Application by Beacon Fen Energy Park Ltd for an order granted development consent for the Beacon Fen Energy Park

Written Representation

**A report prepared by North Kesteven District Council
(ID F8D379496)**

Planning Inspectorate reference: EN010151

Figure 6.32 Vegetation Removal Plan Part 1 (Change Request)

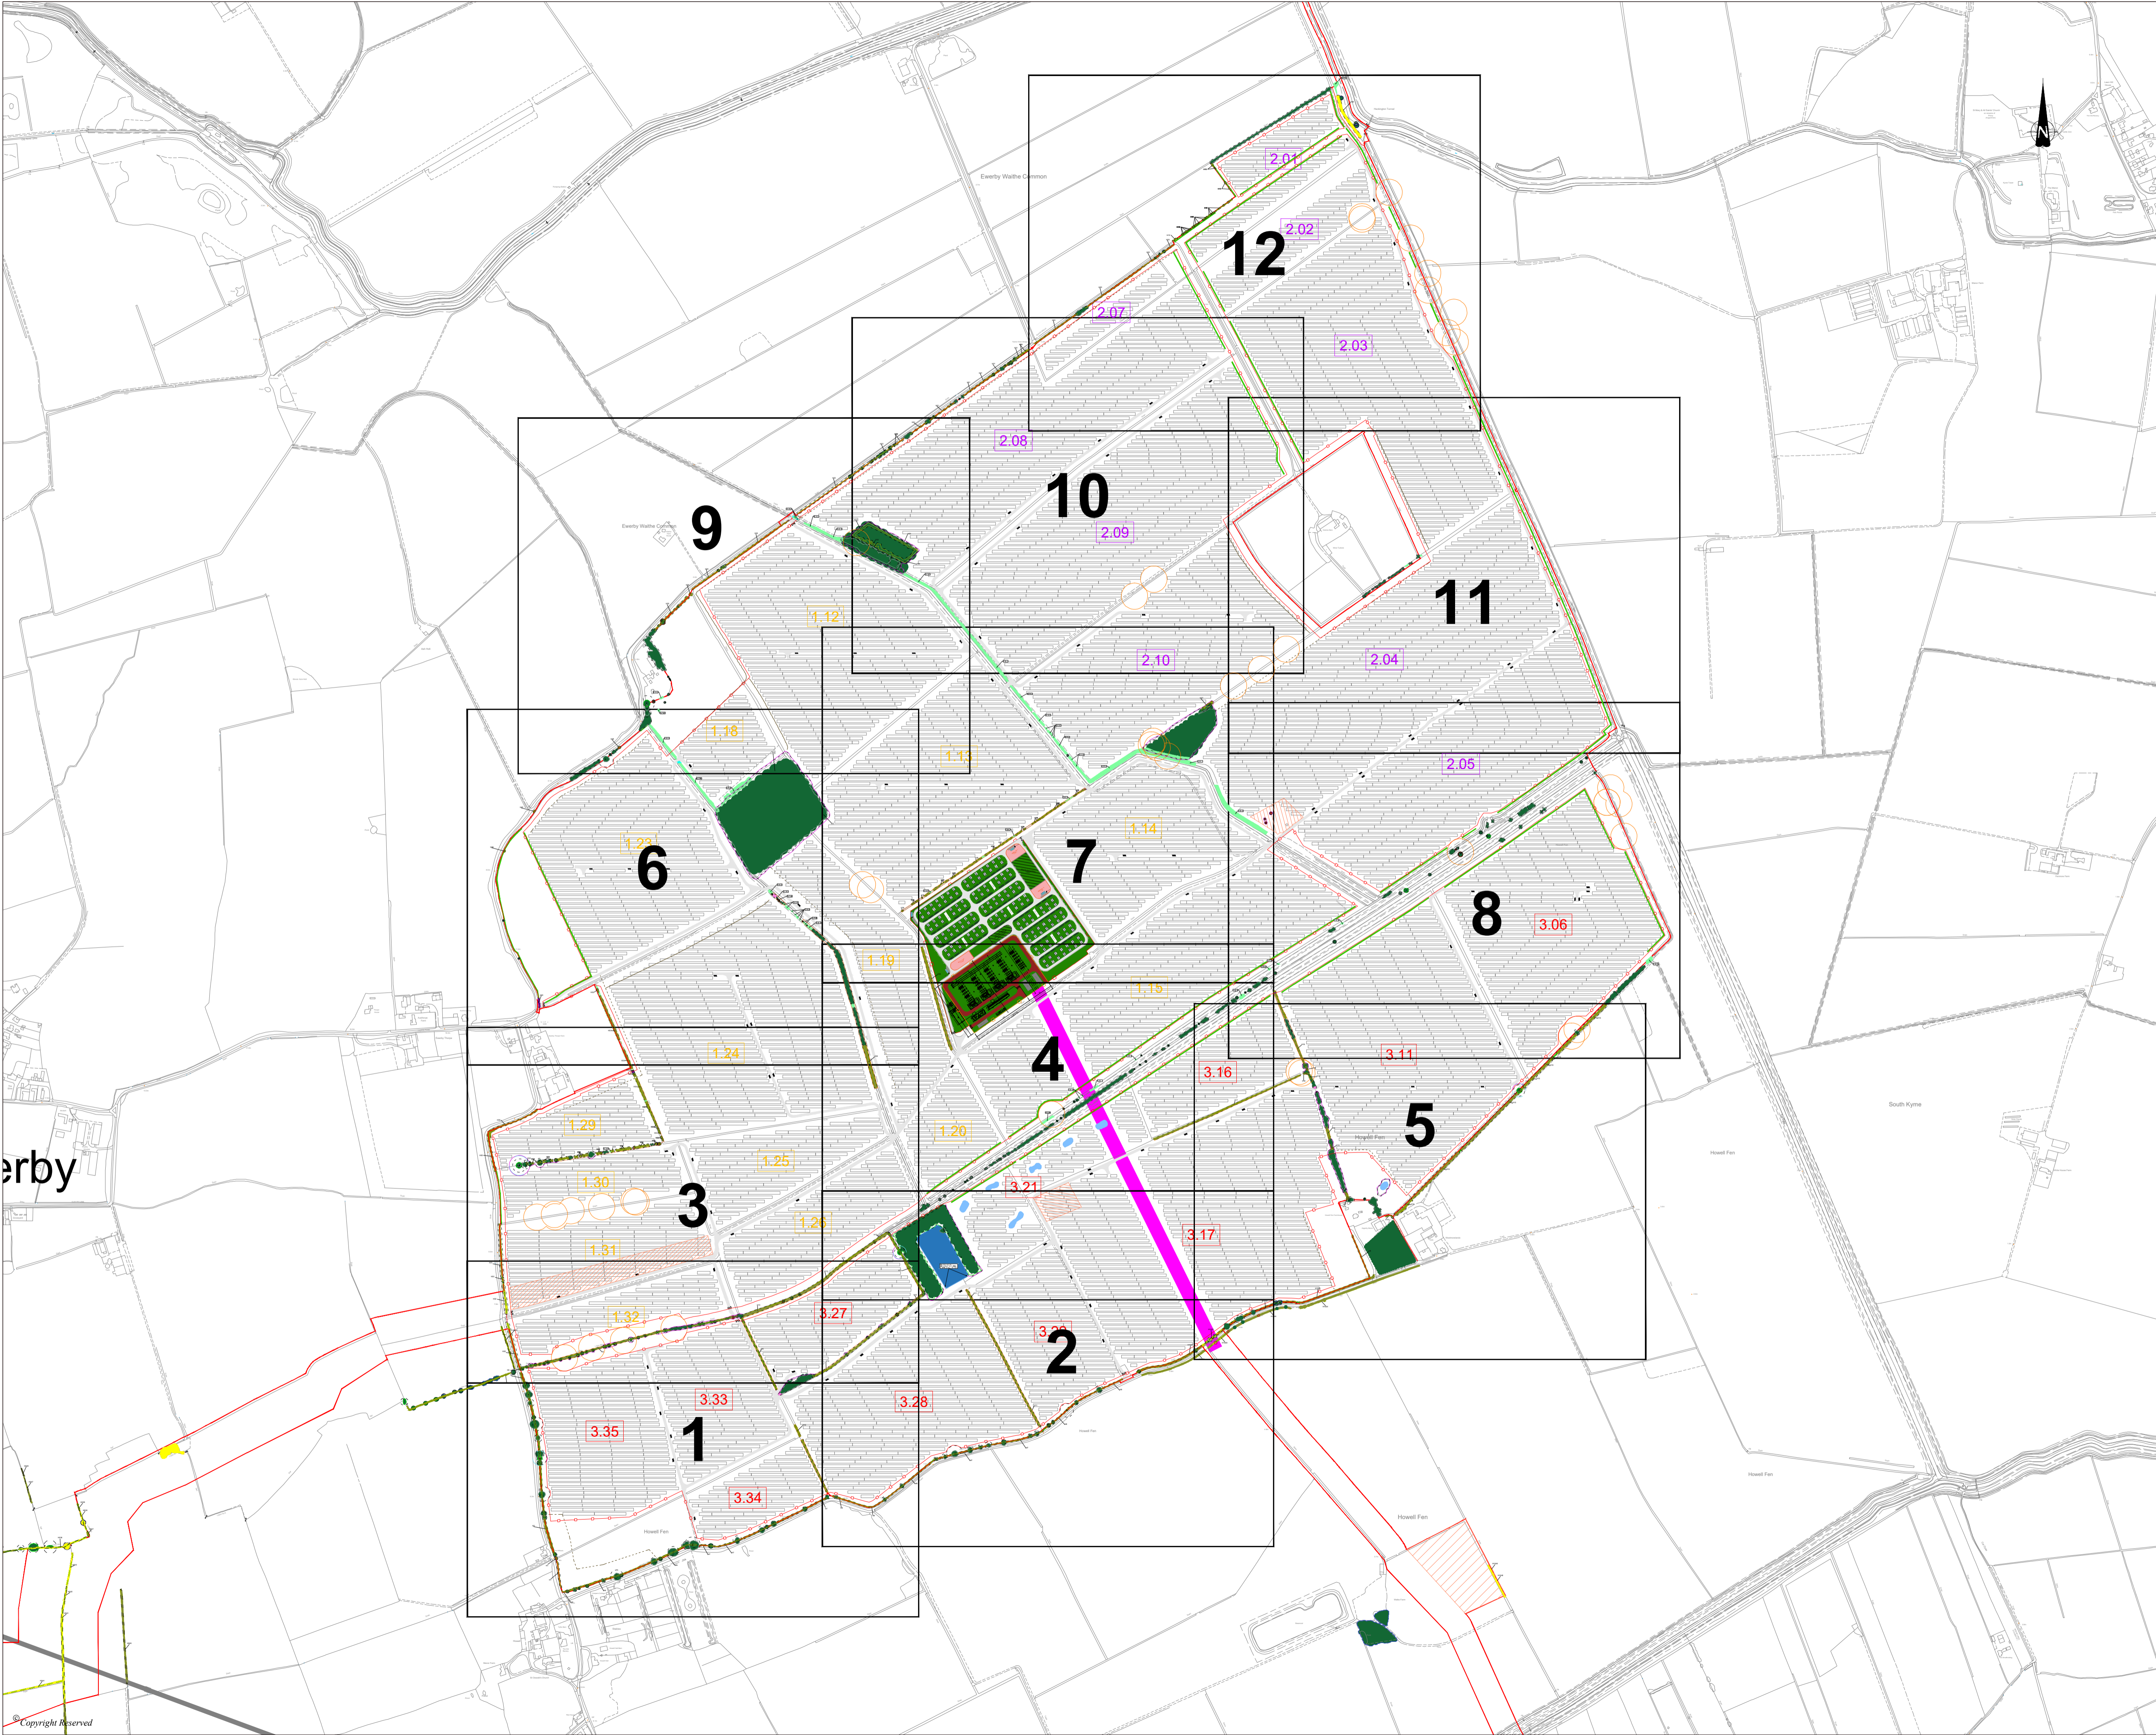
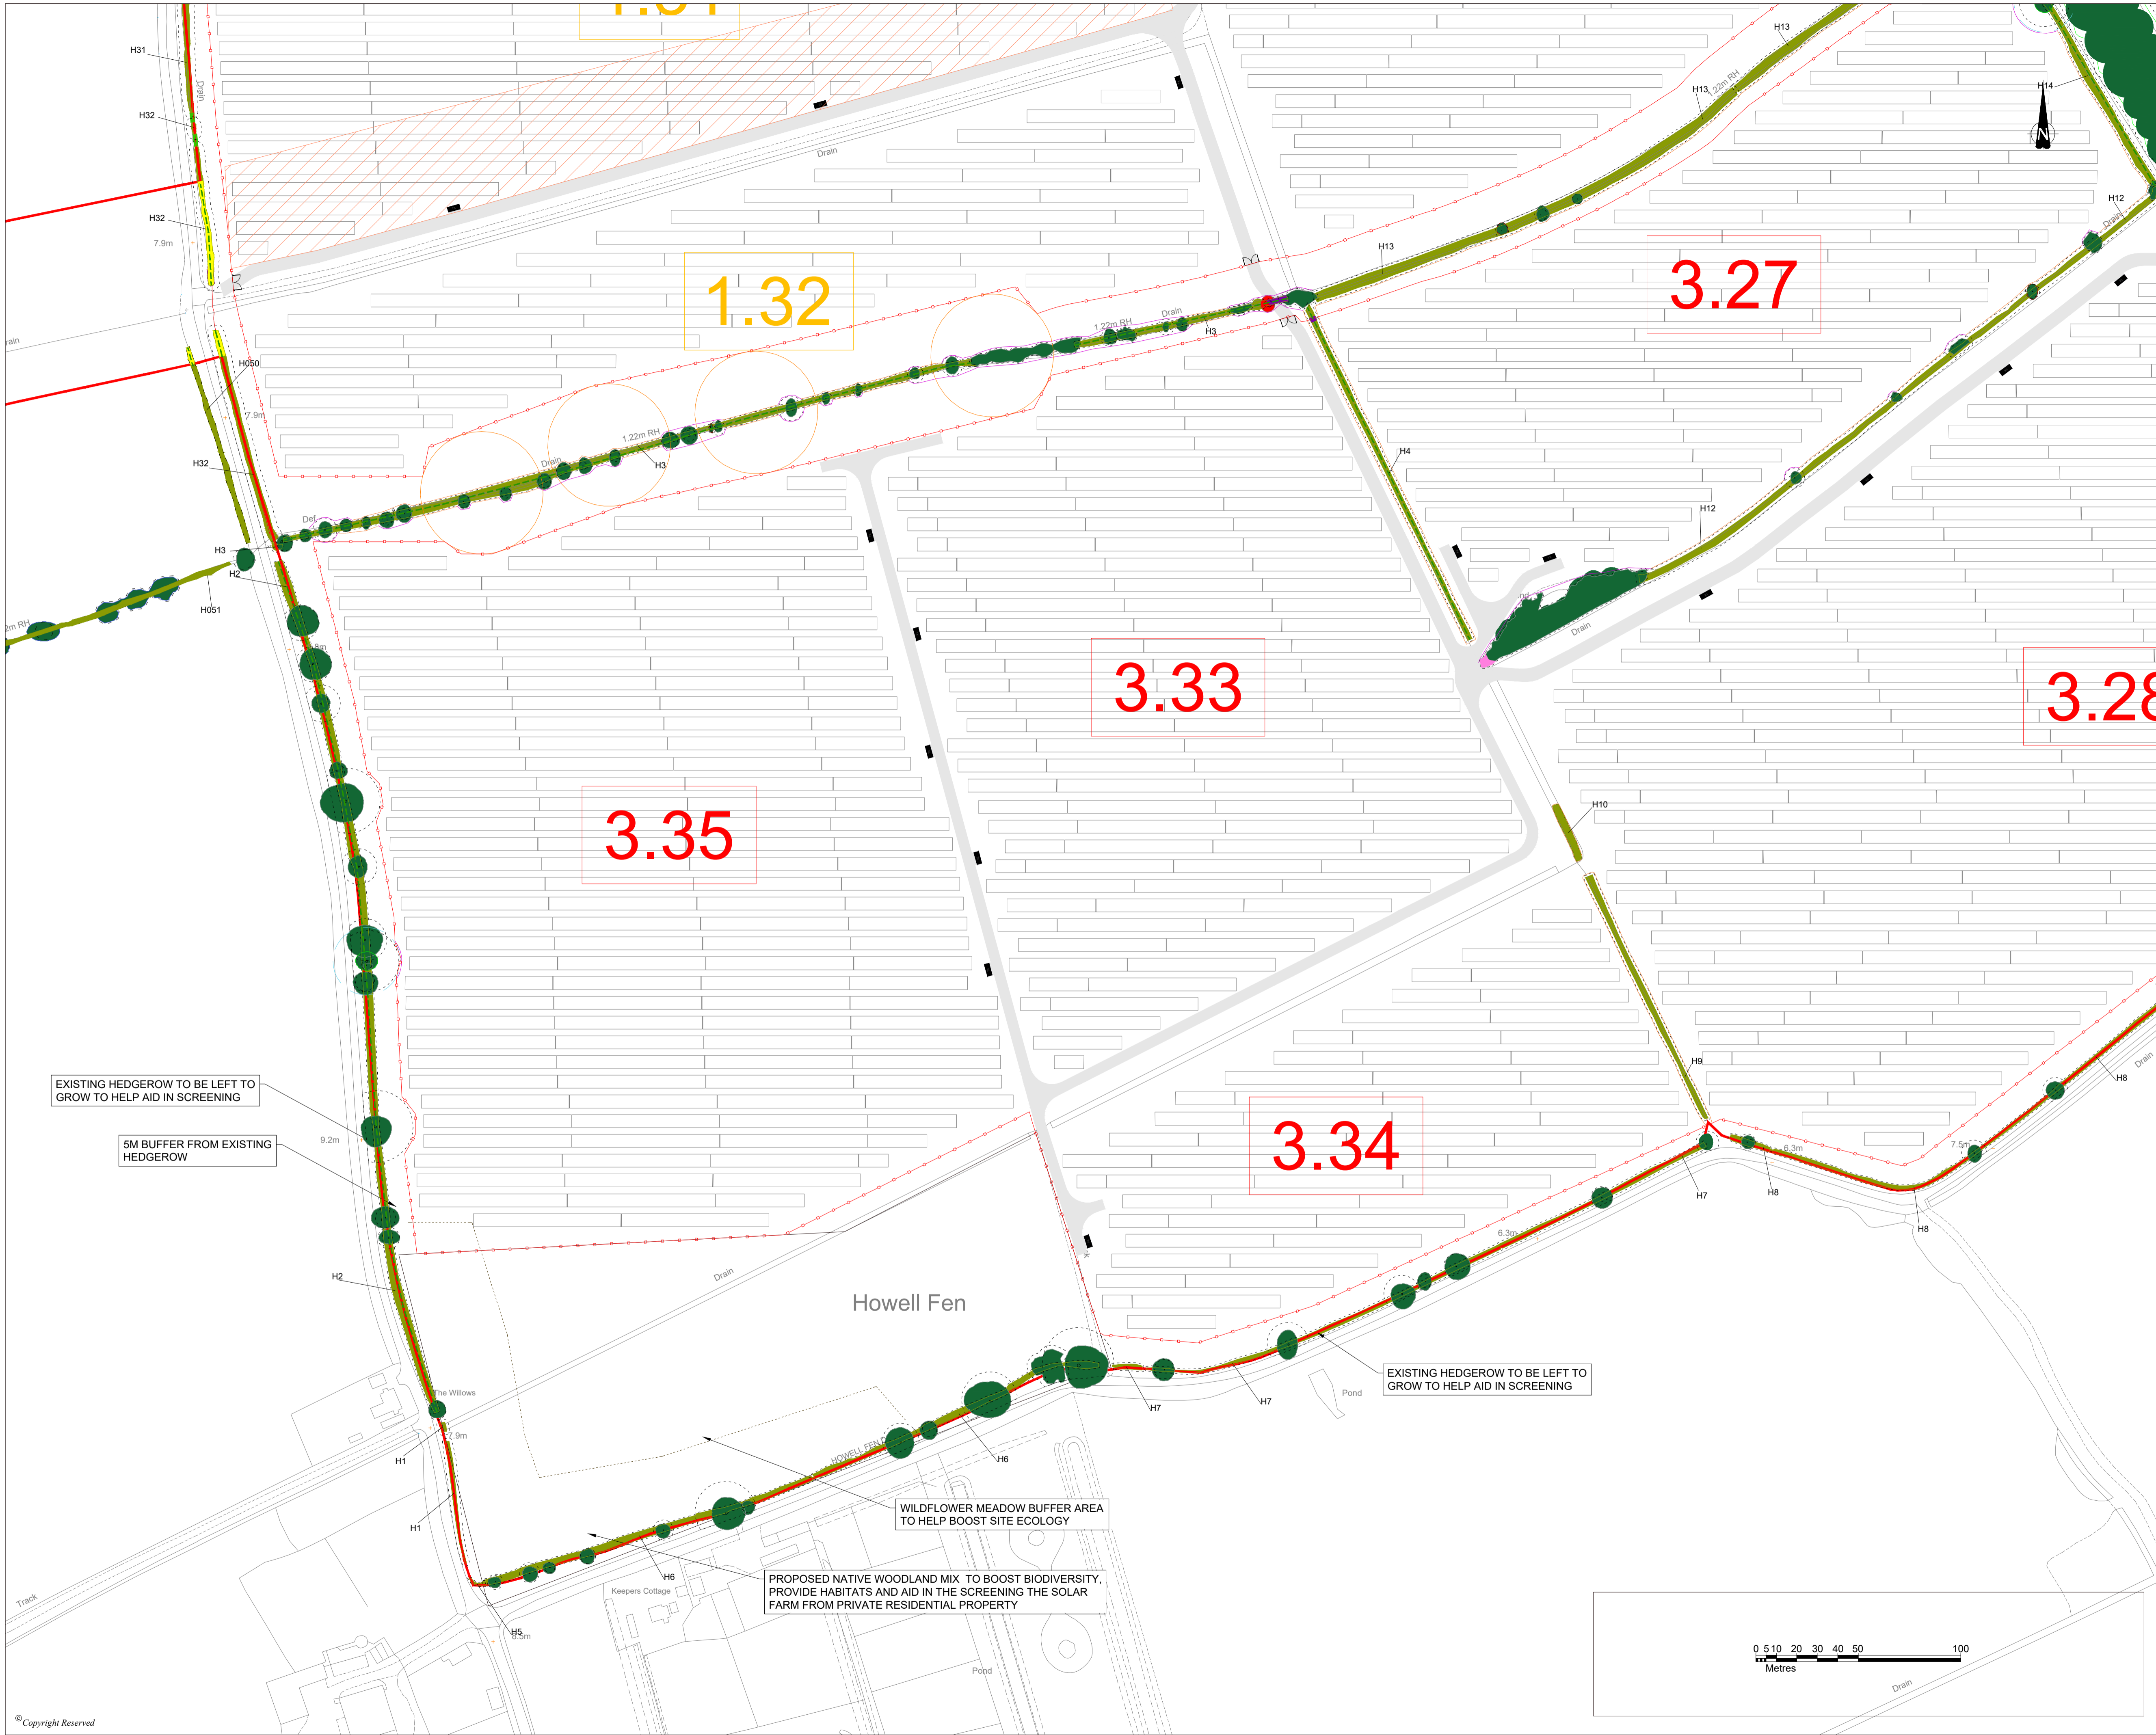
- 4.16 The proposed localised removal of vegetation is identified in the assessment of landscape effects; however, it is unclear whether this includes vegetation works on the wider highways network, and what this would entail. AAH strongly recommend limiting vegetation loss along the site boundaries for access or sight lines, or along construction access routes, because this has the potential to change the character of the local landscape beyond the limits of the development.
